Subject: FW: Application ref: P/108/20/HH - 32 East Front Road, Pagham - Alterations & extension

Subject: Application ref: P/108/20/HH - 32 East Front Road, Pagham - Alterations & extension

I refer to the above application which I am surprised has been registered as it appears to include a number of errors. The application does not include a Design or Access Statement and surely this should be requested.

Rev	Revision	Date
PROJECT		
32 East Front Road, Pagham		
TITLE		
Proposed Site Plan		
DRAWING No. P0009	SCALE (@A1) 1 : 50	Project Ref: J20025
THE EMARRA COMPANY		
www.emarra.co.uk Tel: 07803 924465 Email: info@emarra.co.uk

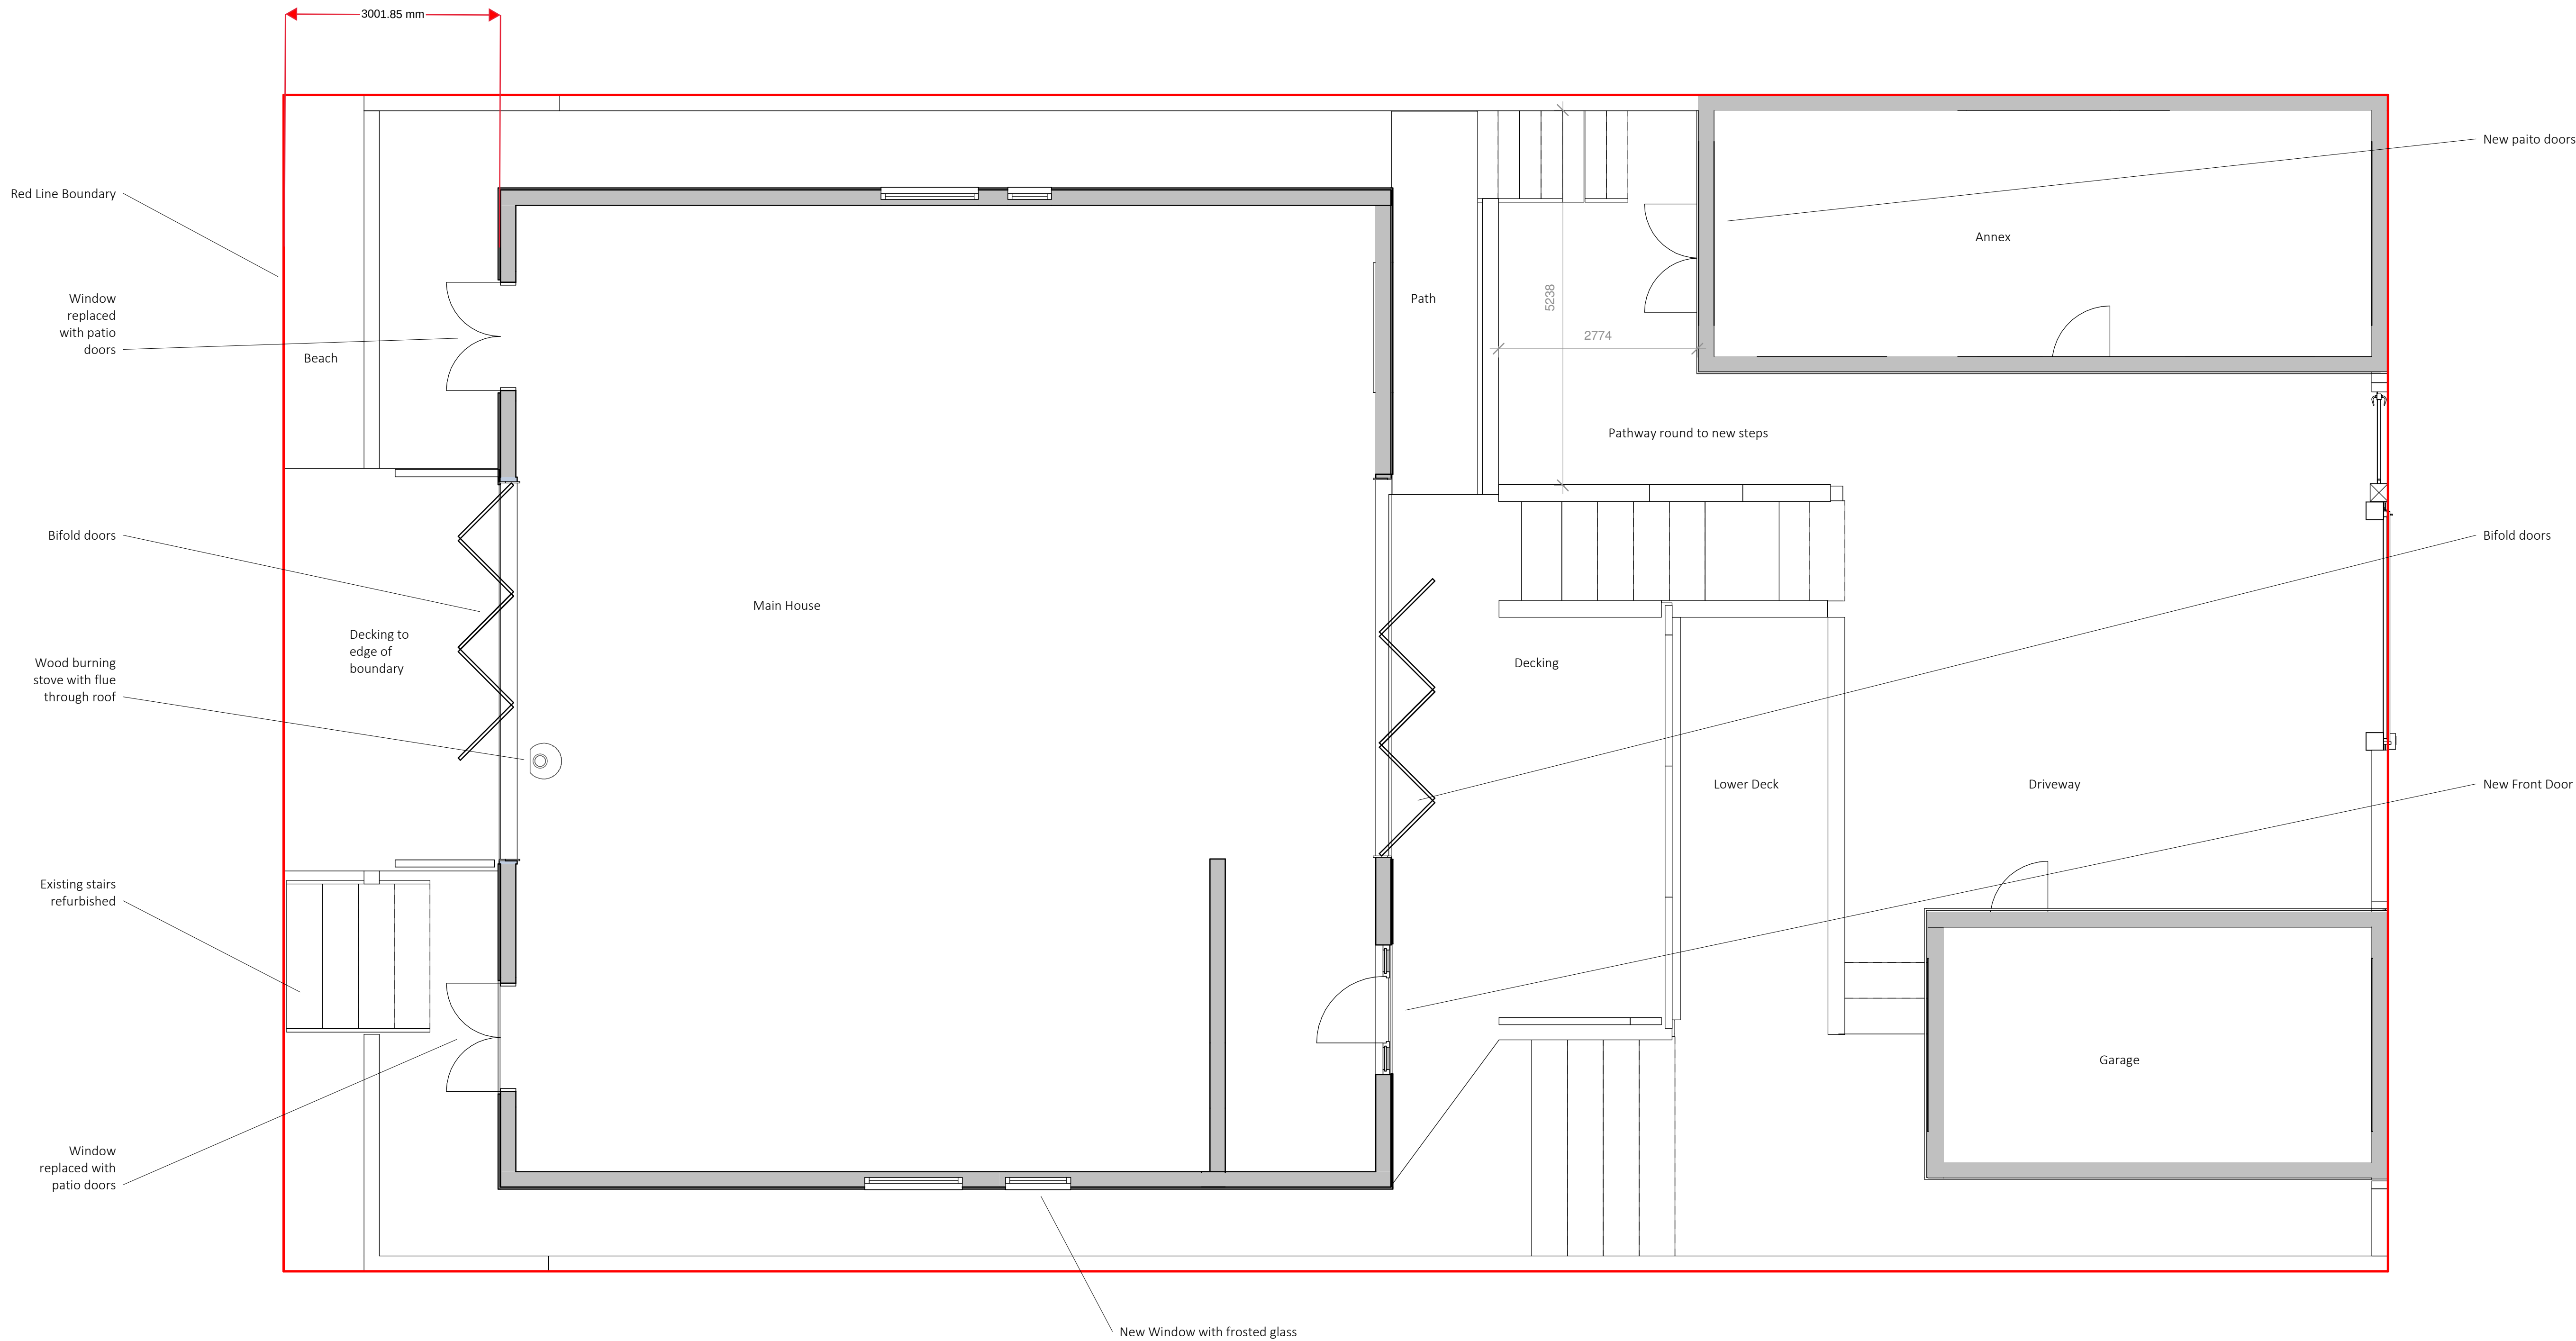
In addition, the agent has misrepresented the site boundary lined in red showing the southeast boundary of the Application Site, and purporting to show an area of the upper beach being included in the Application Site. As the District Council's records will show, the Company owns the beach foreshore down to Mean High Water and I can therefore confirm that the agent's assertion concerning the position of this boundary to be incorrect and the application must be revised to correctly represent the extent of land in the Applicant's ownership. I would also confirm that the agent has not served Notice on the Company of a Planning application submitted over the Company's land.

The boundary between the Application Site and the beach foreshore is formed by the retaining wall that is shown on the agent's Site Plan, and also on the OS Plans included with this application, which correctly show the position of the boundary. As mentioned above this must be clarified with the applicant/agent.

The application at present proposes the formation of steps from a patio adjacent to this boundary, up onto the foreshore, together with the apparent removal of a section of the retaining wall and the installation of decking to encroach onto the foreshore. The removal of part of the retaining wall and the necessary change of levels to the foreshore to accommodate this decking would seem particularly unwise in view of the current quite severe coastal erosion that is occurring to this section of the foreshore and you will see that I have copied this e-mail to the District Council's Coastal Engineer, Roger Spencer, who's views should also be sought.
